From: Laura Gibbons <Laura.Gibbons@arun.gov.uk>
Sent: 28 September 2020 15:22
To: Planning.Responses <Planning.Responses@arun.gov.uk>
Cc: Michael Eastham <Michael.Eastham@arun.gov.uk>
Subject: Y/82/20/RES

Engineers Comments on Surface Water Drainage

Drawing Title Sections through Infiltration Basin

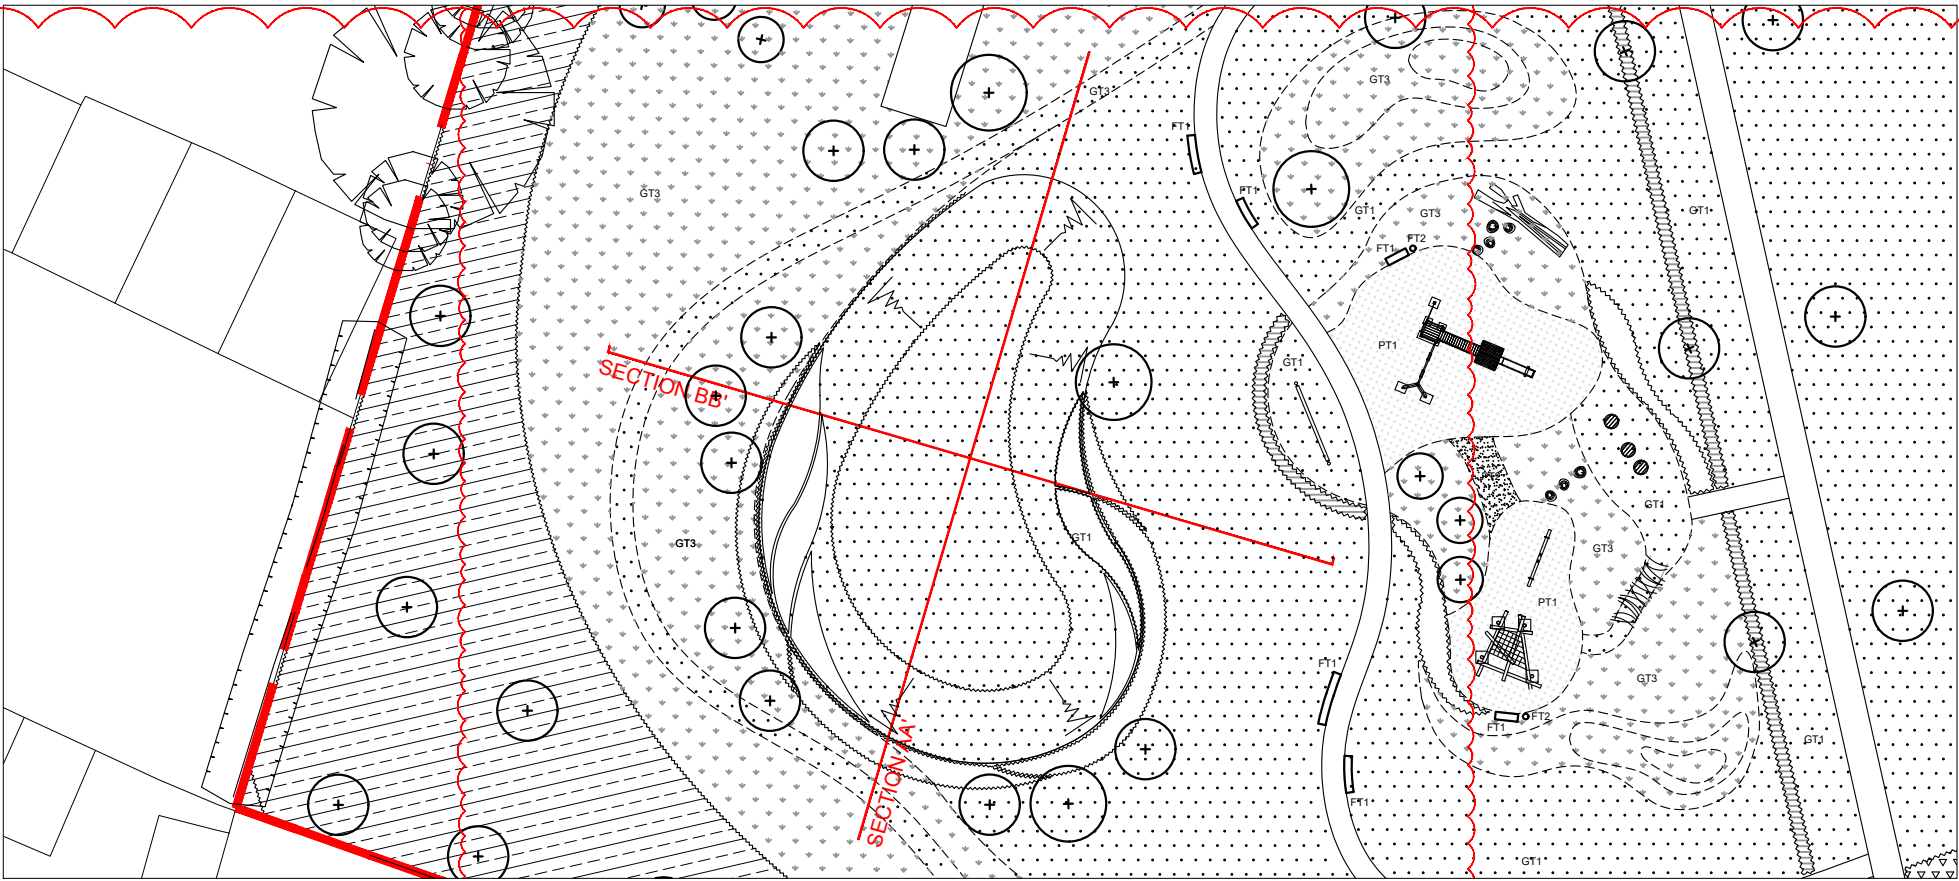
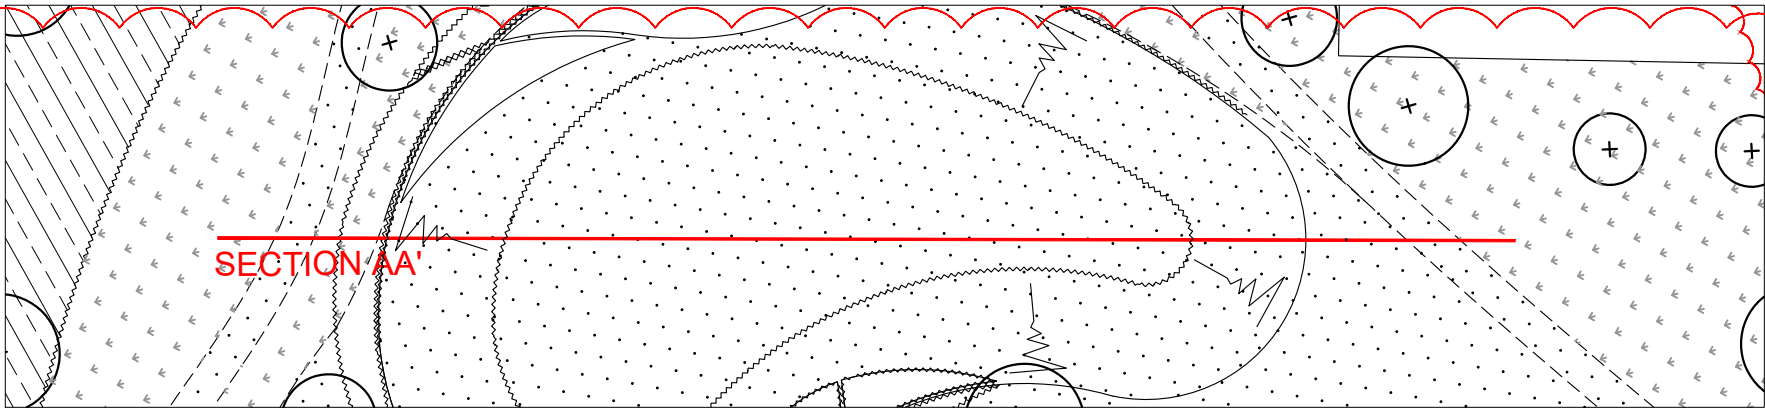
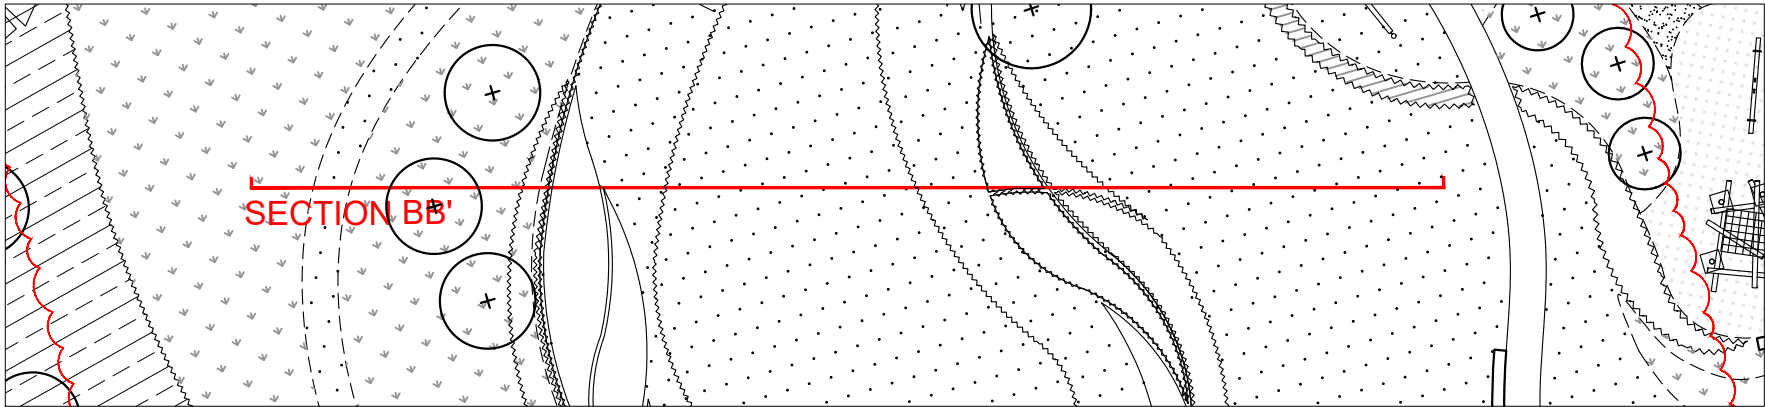
It is understood that the applicant has been in discussions with ADC engineers regarding this site. No drainage strategy has been submitted to support this re-submission for reserved matters approval. Please can the applicant supply a strategy which supports the revised layout. Until this is satisfactorily supplied we wish to raise a **holding objection** to this application.

Evidence should be submitted that demonstrates that there is adequate space within the proposed layout for surface water drainage. E.g. infiltration testing results, peak ground water levels, invert levels of features, half emptying times. Open features should be used where possible, however these should not be counted within the usable open space provision.

3m easement to the watercourse to the south will be required.
